V4_cds.pdf Markup Summary

FOURSQUARE AT STERLING RANCH EAST
FILE NO. 1
PRIVATE PERMANENT CONTROL MEASURE
PRIVATE EXTENDED DETENTION BASIN PLAN SET

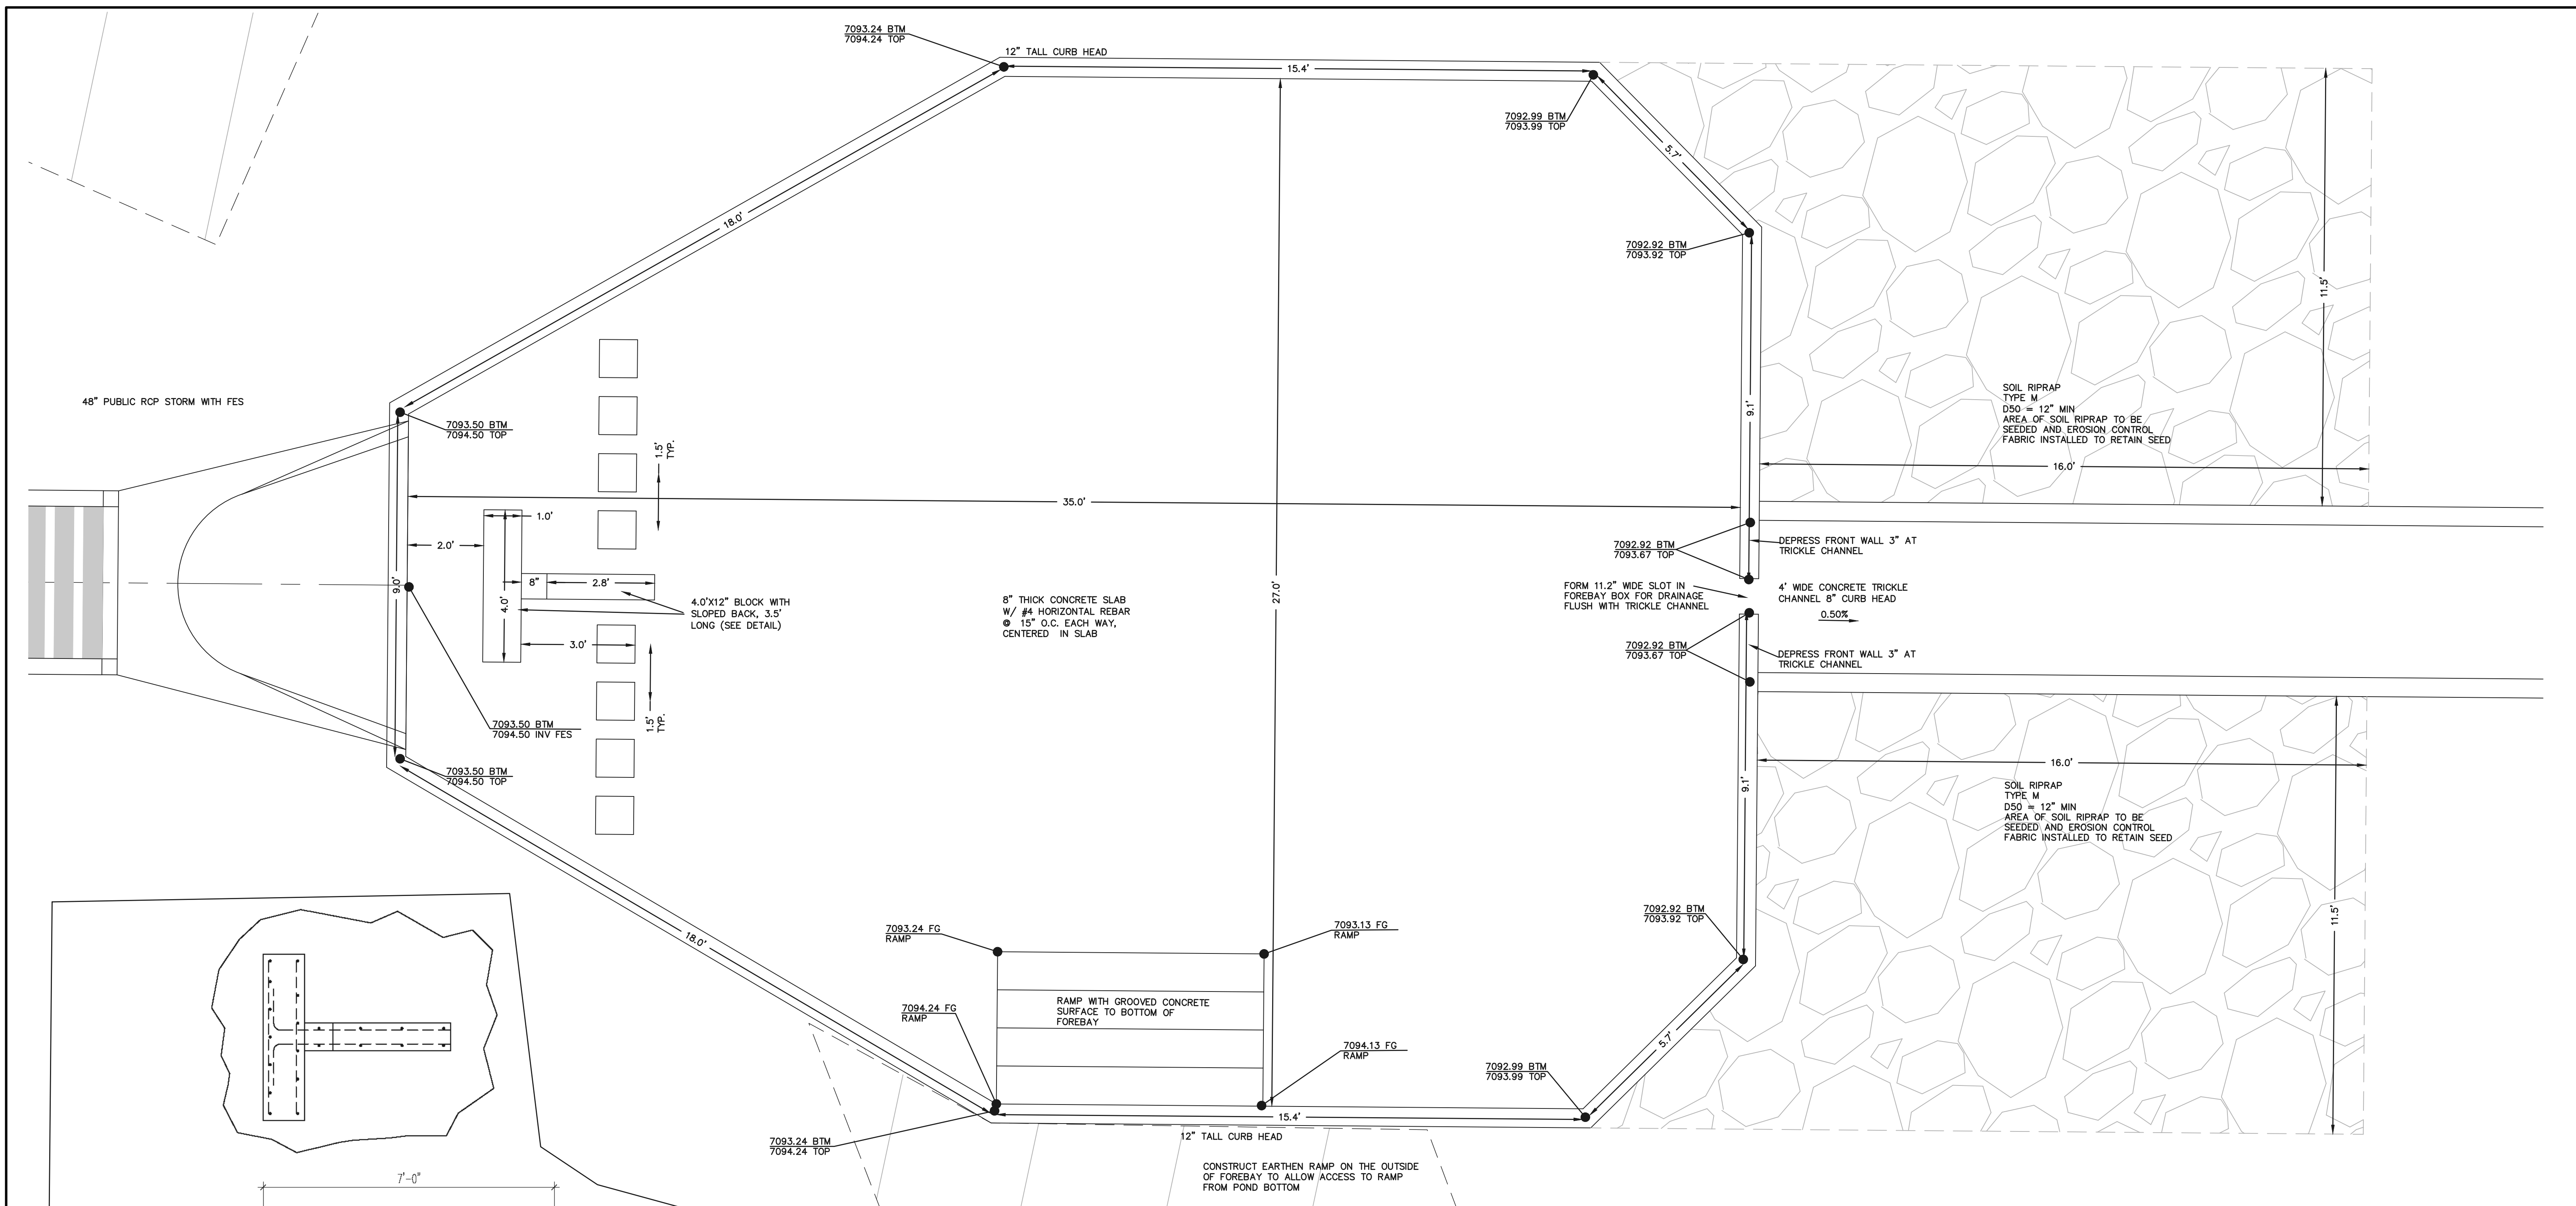
top width might change depending on if you have 4:1 or 6:1 side slopes. See my comments on Sht 27 below.

using 6:1

DESIGNED BY	JRH	SCALE	DATE	08-28-23	DRAWN BY	JRH	(H) 1"= 5'	SHEET	26 OF 29	CHECKED BY		(V) 1"= N/A	JOB NO.	1183.23
DESIGNED BY	JRH	SCALE	DATE	08-28-23														
DRAWN BY	JRH	(H) 1"= 5'	SHEET	26 OF 29														
CHECKED BY		(V) 1"= N/A	JOB NO.	1183.23

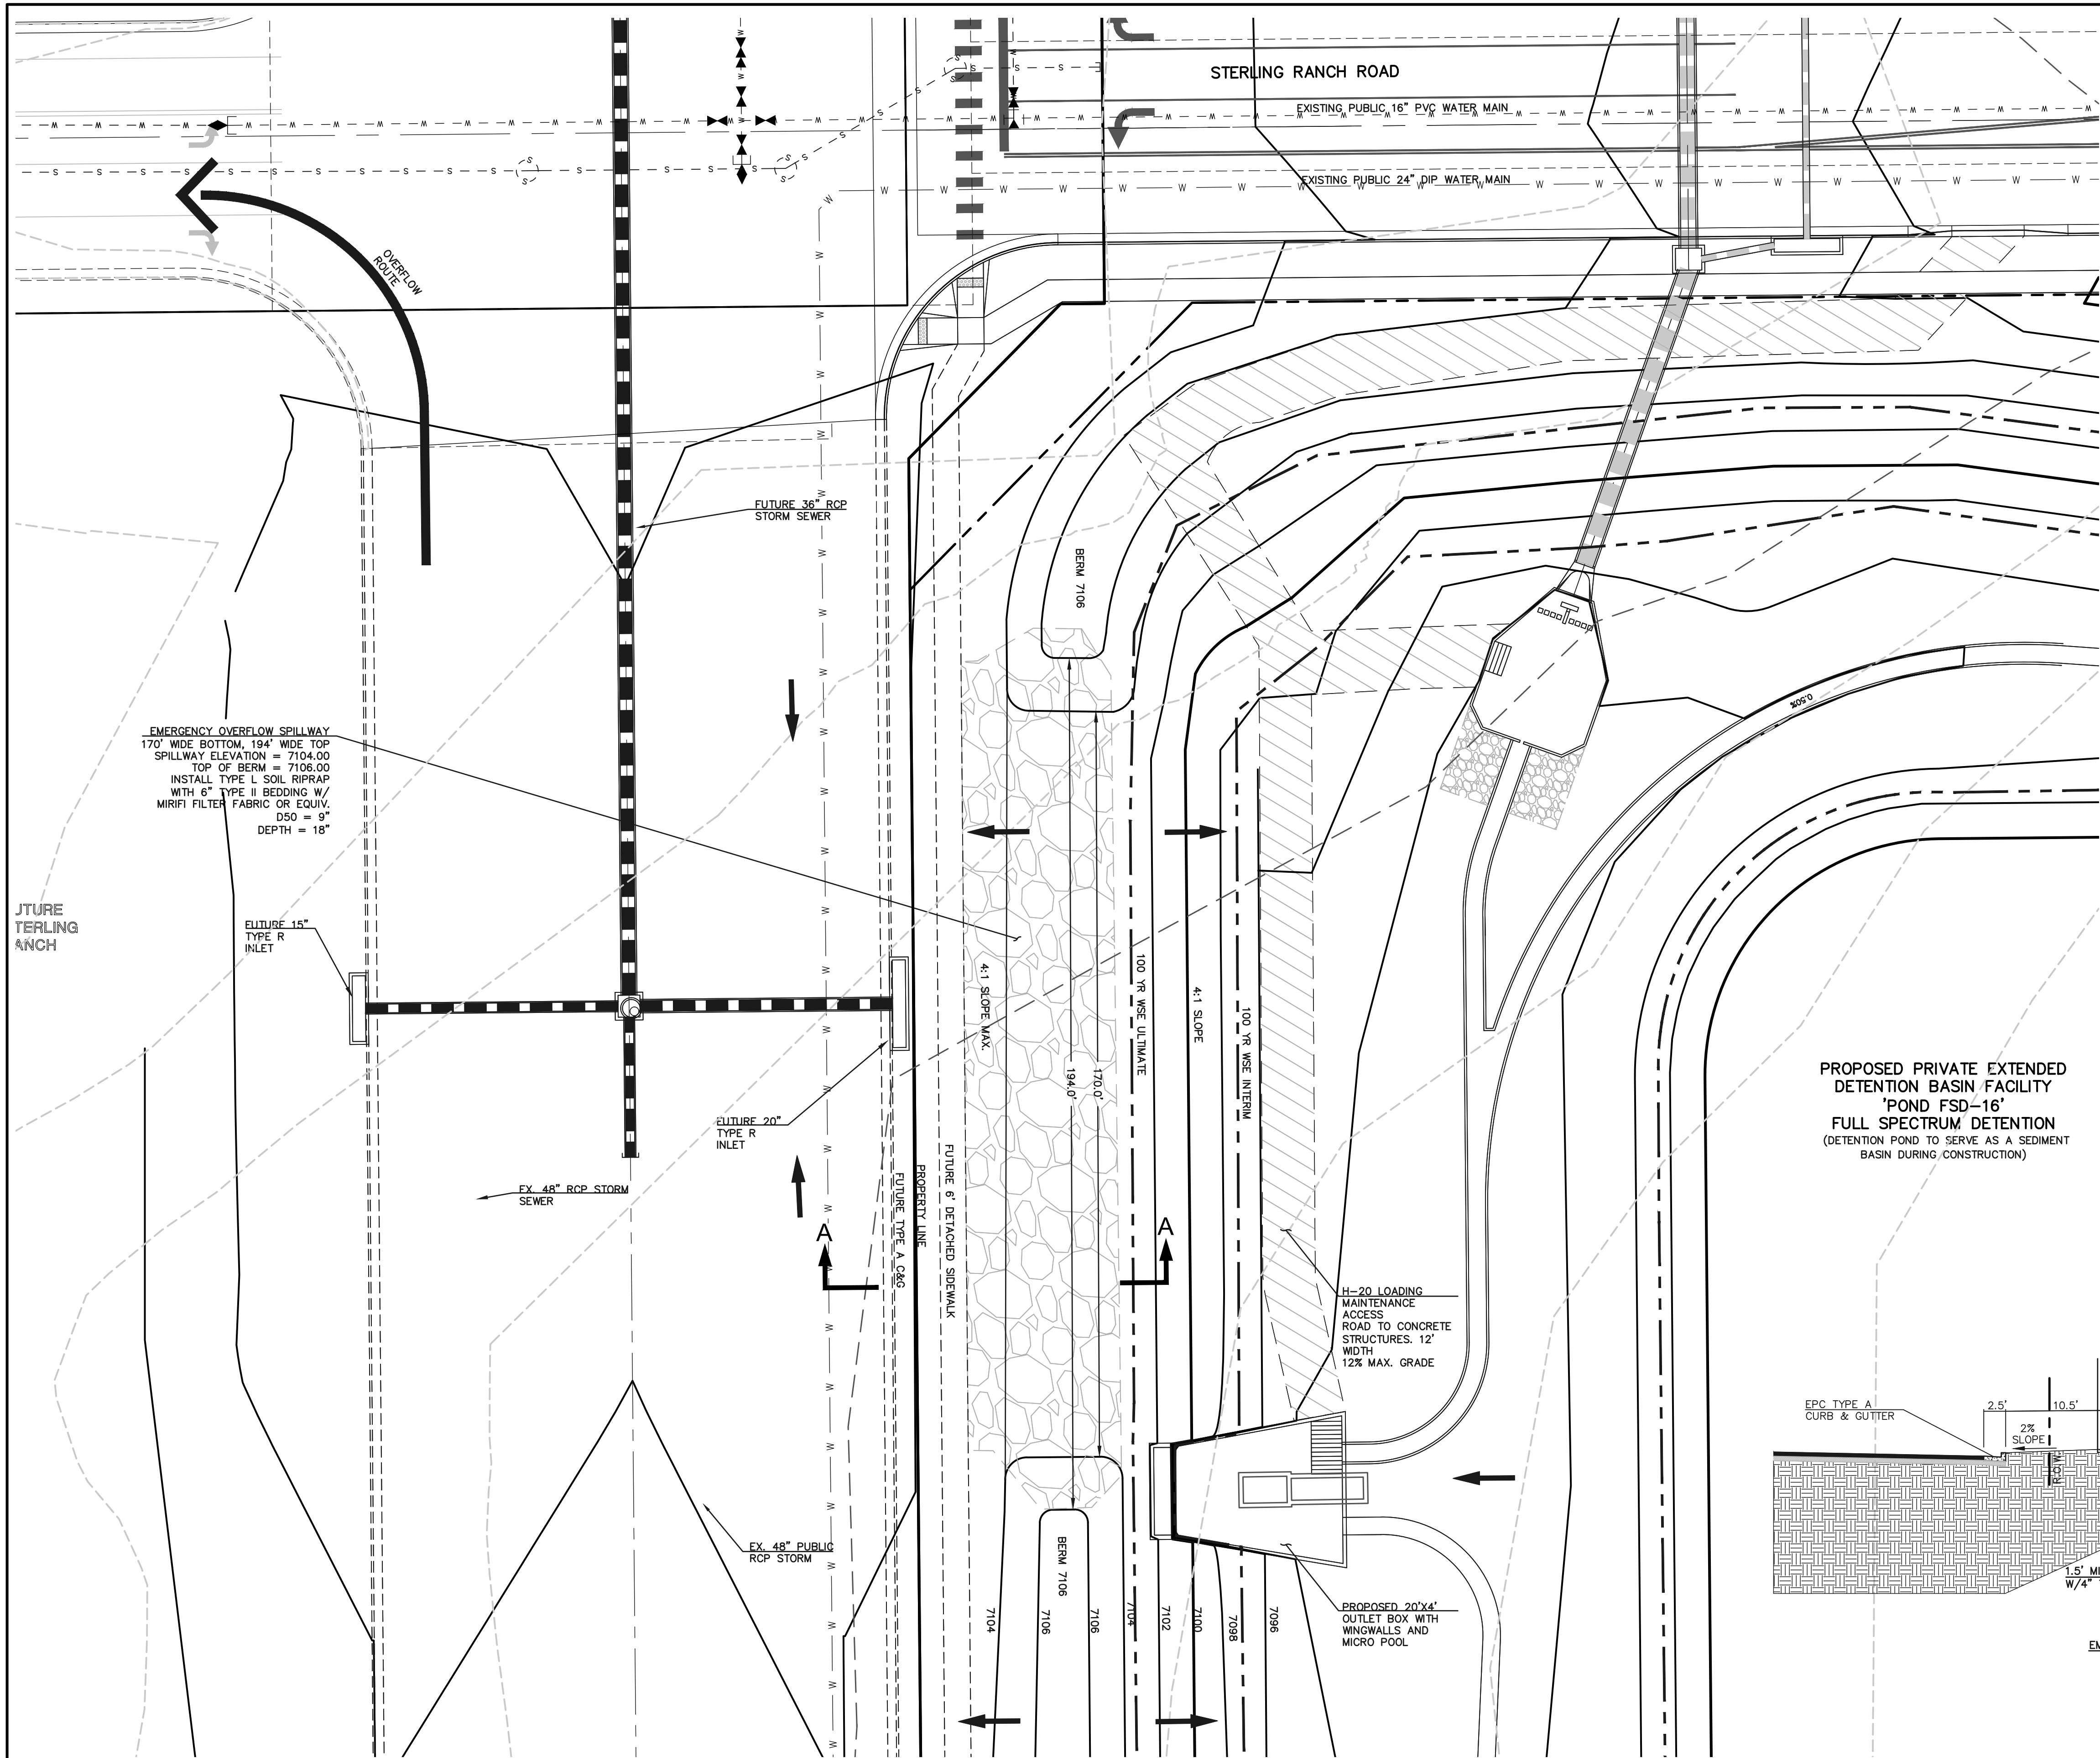
Pond spreadsheet in FDR shows 6:1 side slopes. Please reconcile between report and drawings to show same slope.

Shown as 6:1 on FDR calcs on pdf pg 98

using 6:1

using 6:1
